CITY OF ALBUQUERQUE

Re: M&M Smoke Shop
1800 Central SE
Traffic Circulation Layout
Engineer's/Architect's Stamp **5-26-16** (K15-D100)

Based upon the information provided in your submittal received 5-26-16, the above referenced plan cannot be approved for Building Permit until the following comments are addressed:

SITE PLAN

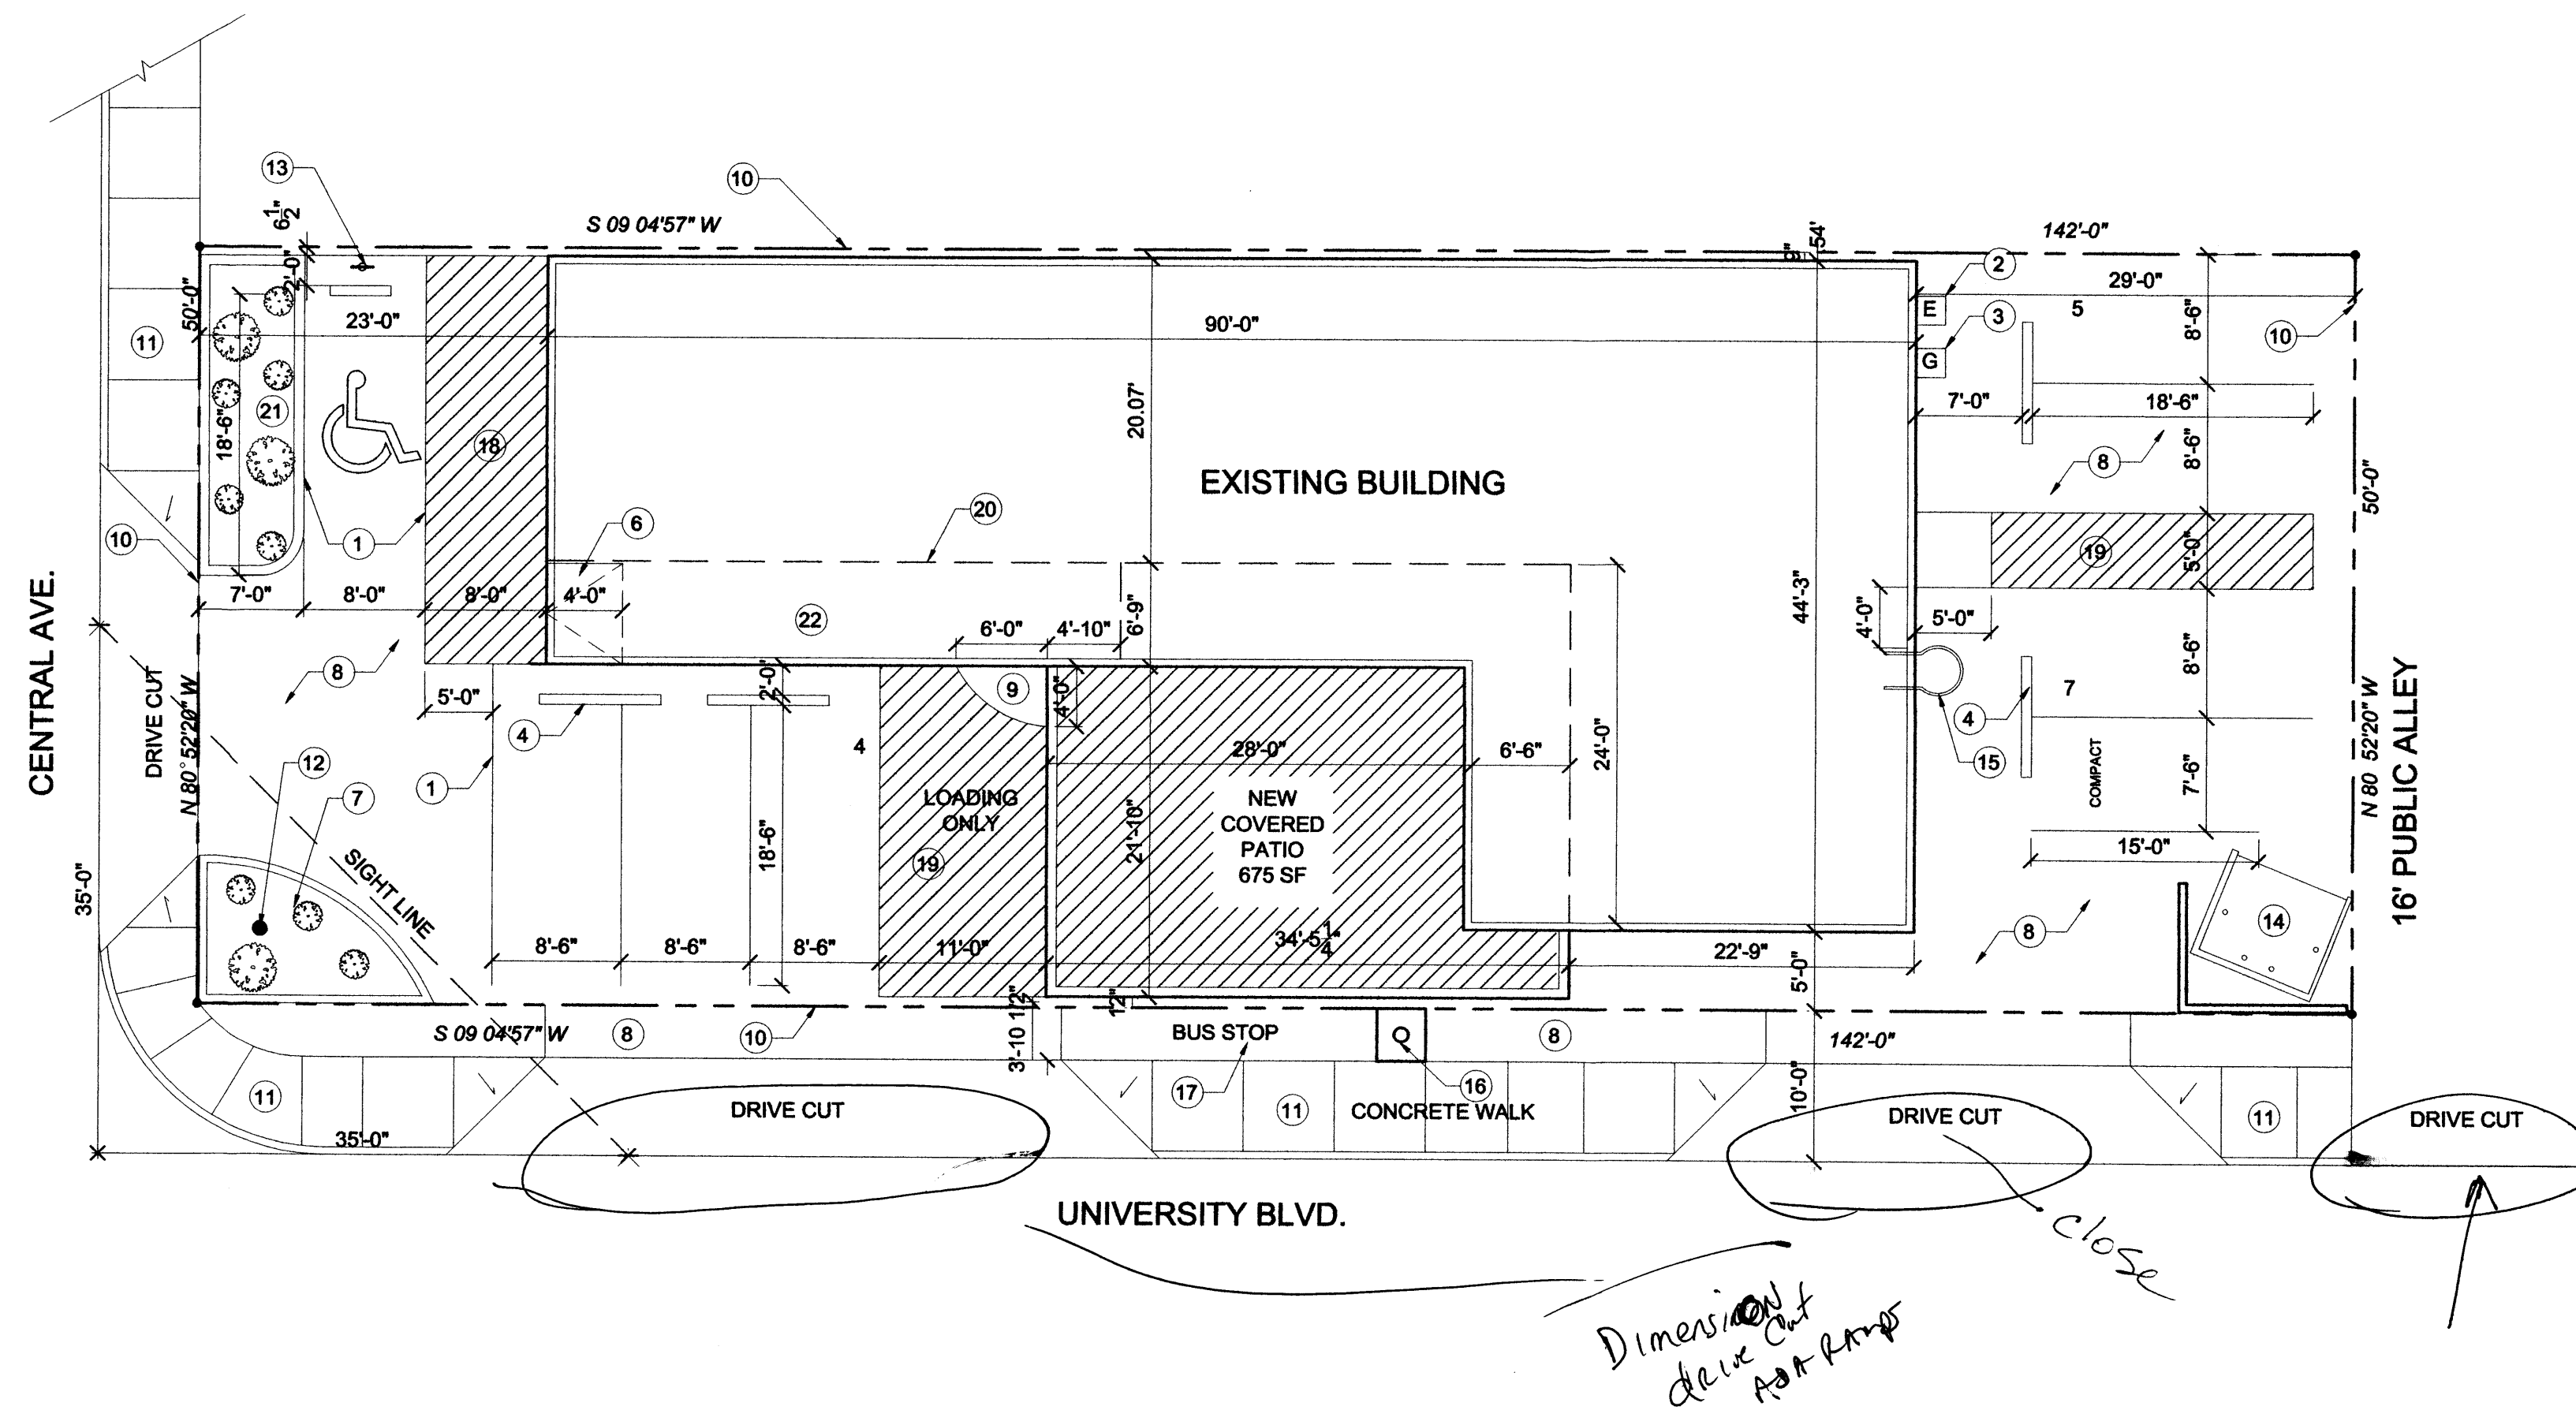
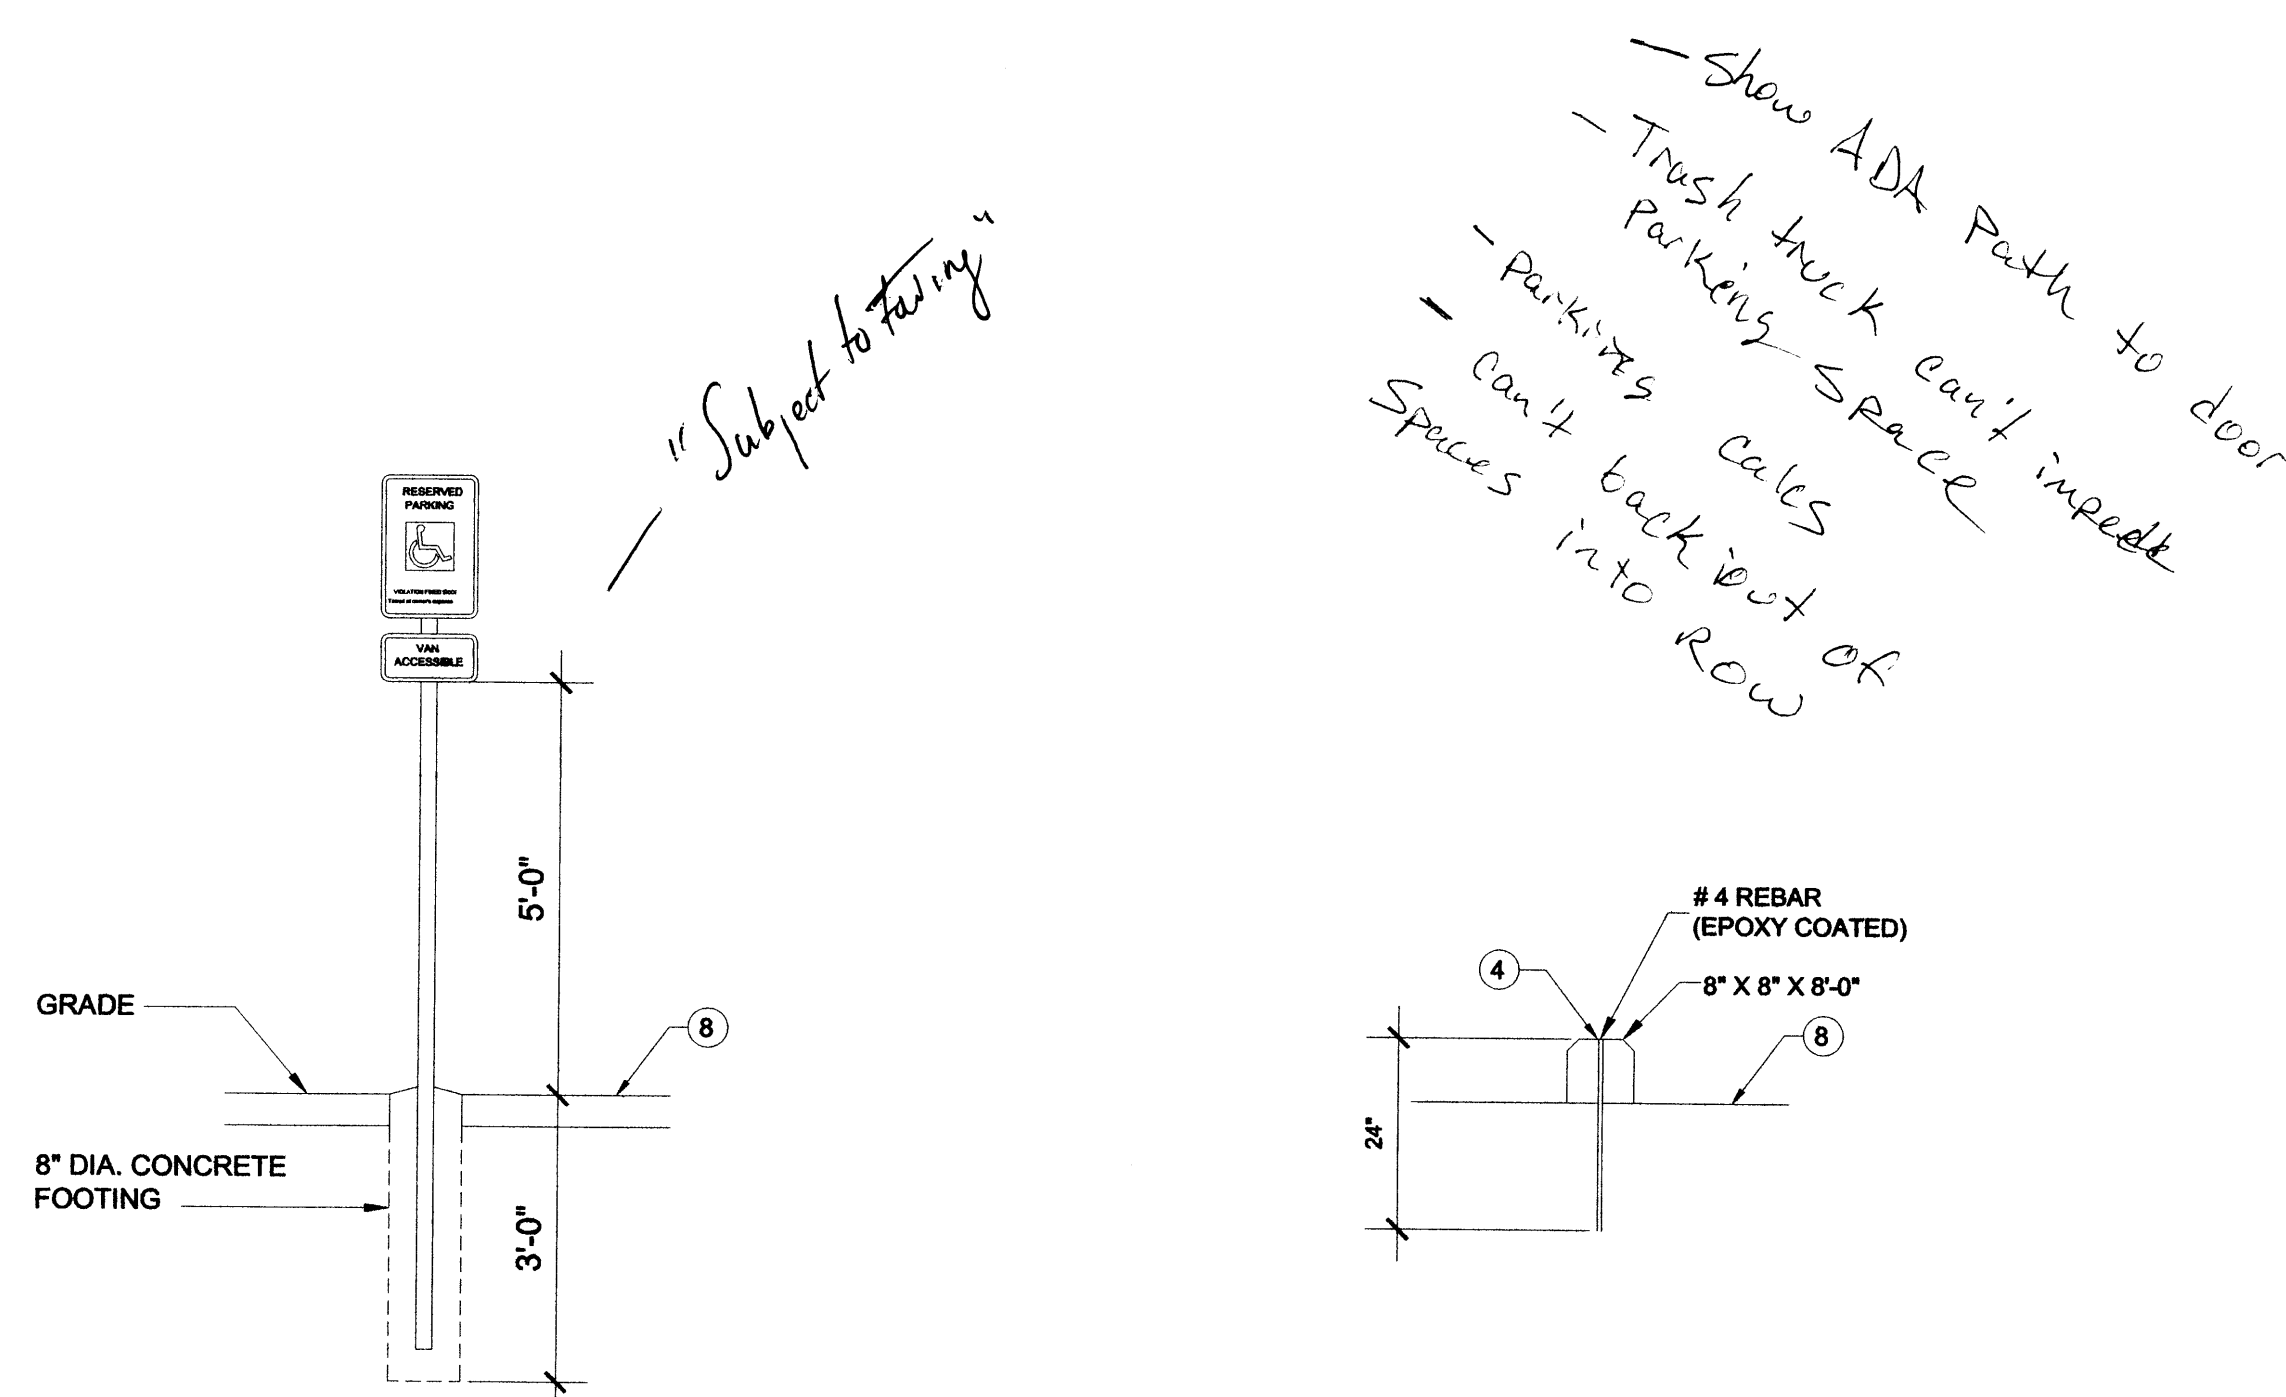
1. Please show a vicinity map showing the location of the development in relation to streets and well known landmarks.
2. List the number of parking spaces required by the zoning code as well as the proposed number of parking spaces.

3. Please identify all existing buildings, doors, structures, sidewalks, curbs, drive pads, wall and anything that influences the parking and circulation on the site.

4. Please detail and dimension all existing curb cuts and ADA ramps.
5. Identify all existing access easements and rights of way width dimensions.
6. Identify the right of way width, medians, curb cuts, and street widths on Central Ave. and University Blvd.

9. Show all drive aisle widths and radii.
10. Per DPM, a 6 ft. wide ADA accessible pedestrian pathway is required from the public sidewalk to the building entrances. Please clearly show this pathway and provide details.

11. Per DPM, a 6 ft. wide ADA accessible pedestrian pathway is required from the HC parking stall access aisles to the building entrances. Please clearly show this pathway and provide details.

PO Box 1293

13. Design delivery vehicle route needs to be shown.
14. Service vehicle and/or refuse vehicle maneuvering must be contained on-site; provide a copy of refuse approval. Trash trucks cannot impede parking spaces.

15. Please provide a sight distance exhibit (see the *Development Process Manual, Chapter 23, Section 3*). Please show detail from the exit/entrance off of the public alley.

16. Please add the following note to the clear sight triangle: "Landscaping and signage will not interfere with clear sight requirements. Therefore, signs, walls, trees, and shrubbery between 3 and 8 feet tall (as measured from the gutter pan) will not be acceptable in this area."

17. Unused curb cuts must be replaced with sidewalk and curb & gutter. A build note must be provided referring to the appropriate City Standard drawing. The curb cut on the south west side of building must be removed and replaced with COA standard curb and gutter.

18. It is not permissible for vehicles to back out onto University Blvd. from the parking stalls. Please provide and detail signs and pavement markings stating direction of exit.

19. All broken or cracked sidewalk must be replaced with sidewalk and curb & gutter. A build note must be provided referring to the appropriate City Standard drawing.

1 ADA VAN SIGN DETAIL
SCALE 1/2" = 1'-0"

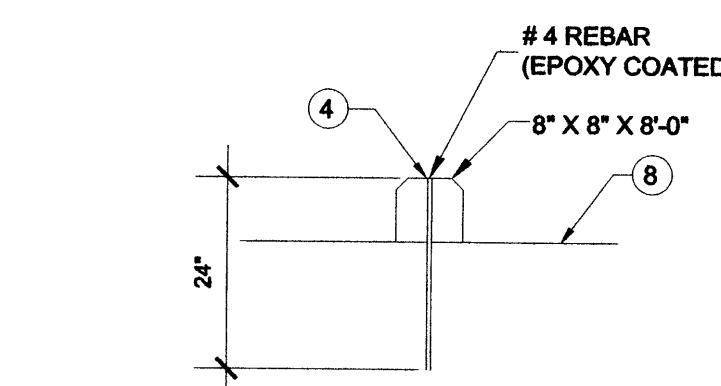
7. The ADA accessible parking sign must have the required language per 66-7-352.4C NMSA 1978 **"Violators Are Subject to a Fine and/or Towing."** Please call out detail and location of HC signs. Please show this detail.

4 LANDSCAPE CURB DETAIL
SCALE 1/2" = 1'-0"

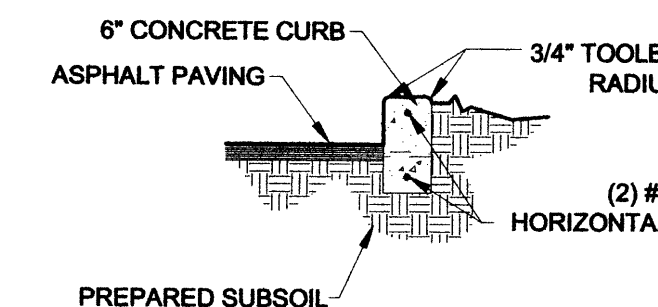
12. Provide a min 6" or max 8" high concrete barrier curb or other acceptable barrier between landscaping and parking areas and/or drive aisles. Please call out detail and location of barrier curb.
